14 October 2010

Ms Christine Chapman
Major Development Assessment
NSW Department of Planning
23-33 Bridge Street
SYDNEY NSW 2000

**Riverina Oils and Bio Energy
Integrated Oilseed Processing Facility (MP06 – 0239 MOD 1)**

Figure 28: Amended Elevations for the IOPP (without the Biodiesel component)

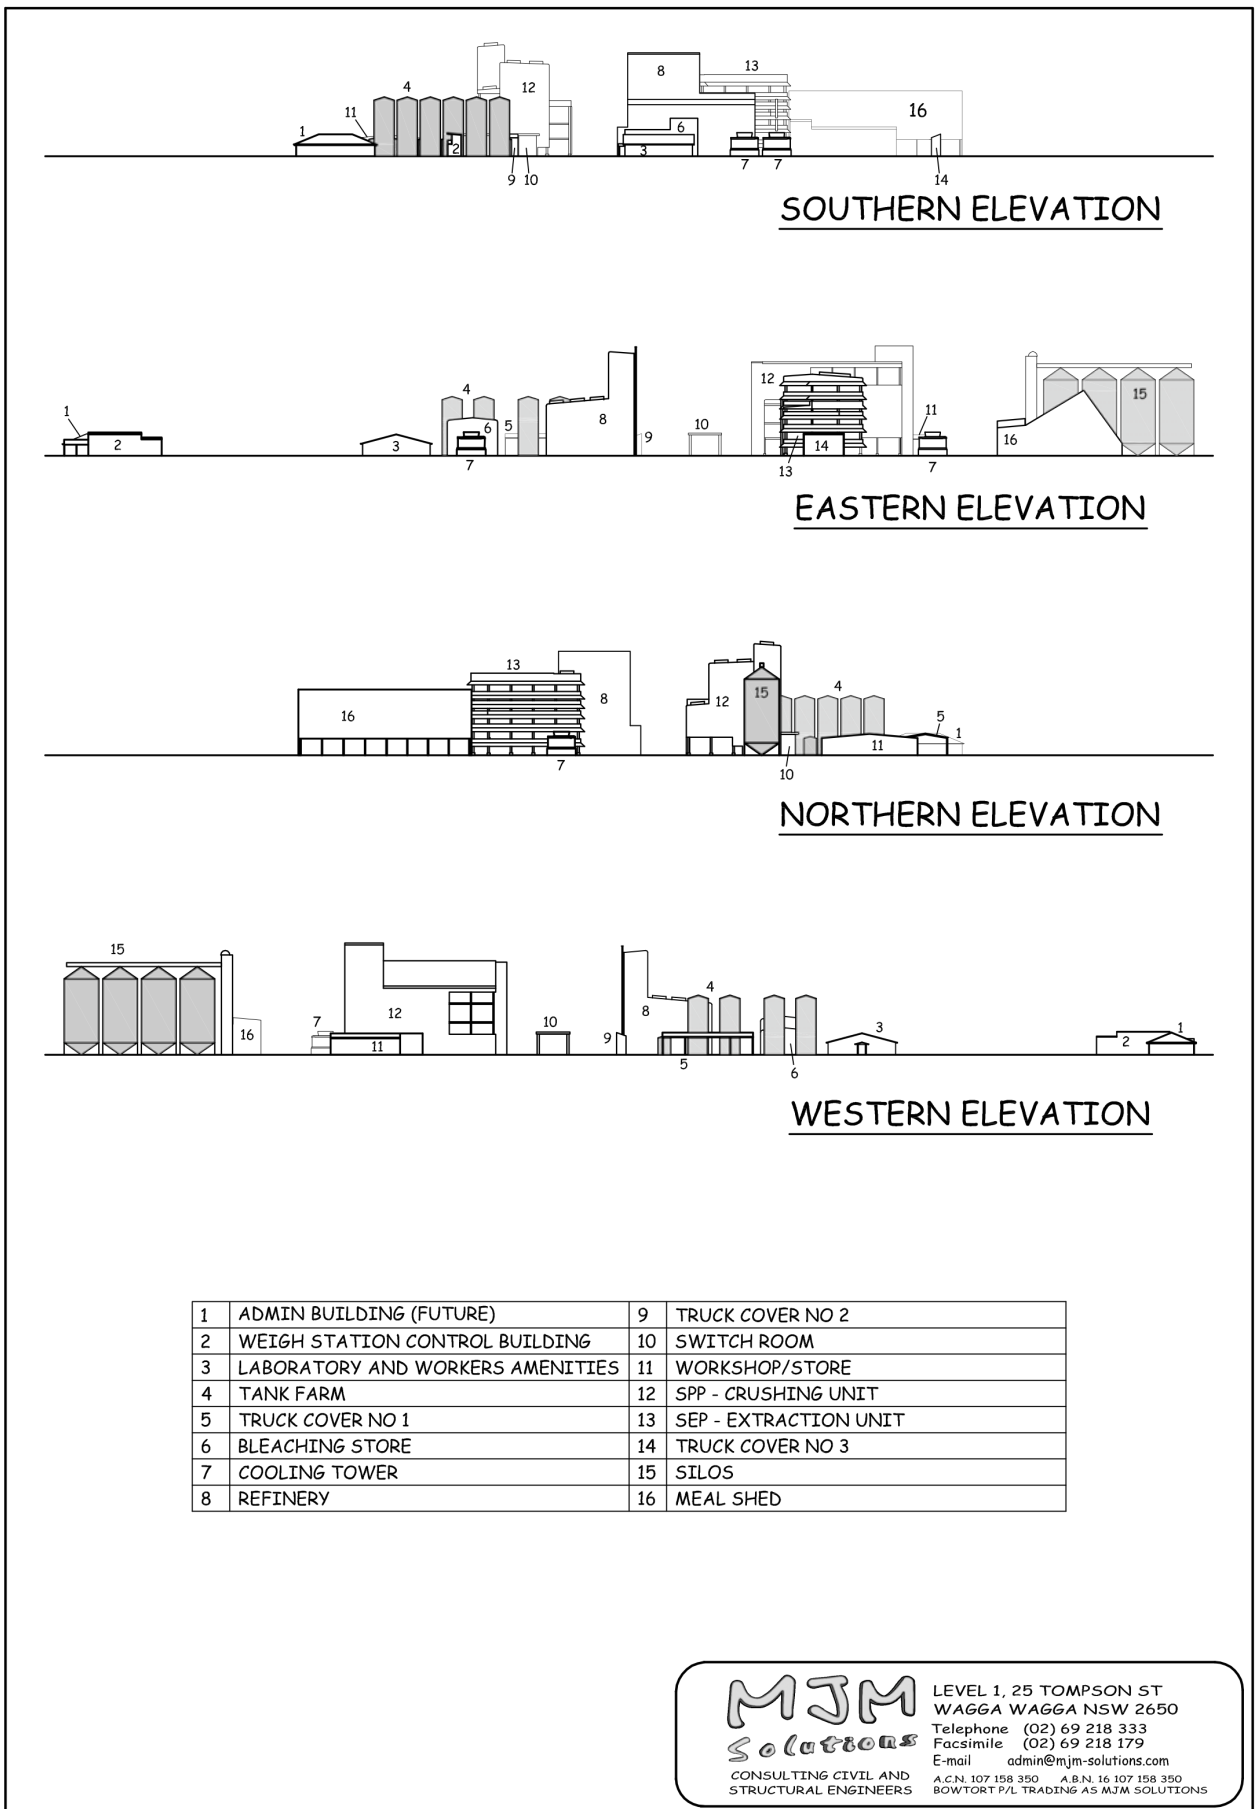
1. The increased height of a number of the buildings that may have a significant impact on the landscape and should be carefully considered. Whilst a greater height minimises the likely odour impacts there are also visual and amenity issues to consider, particularly with regard to the location of the buildings on existing elevated land as it may have a negative impact on the existing natural and physical landscape and visual amenity.

3. Lighting of the plant may introduce a significant and adverse change to the rural environment. Measures should be considered that minimise light spillage towards rural properties. Consideration should be given to the height to which light is allowed to be placed on the taller buildings.
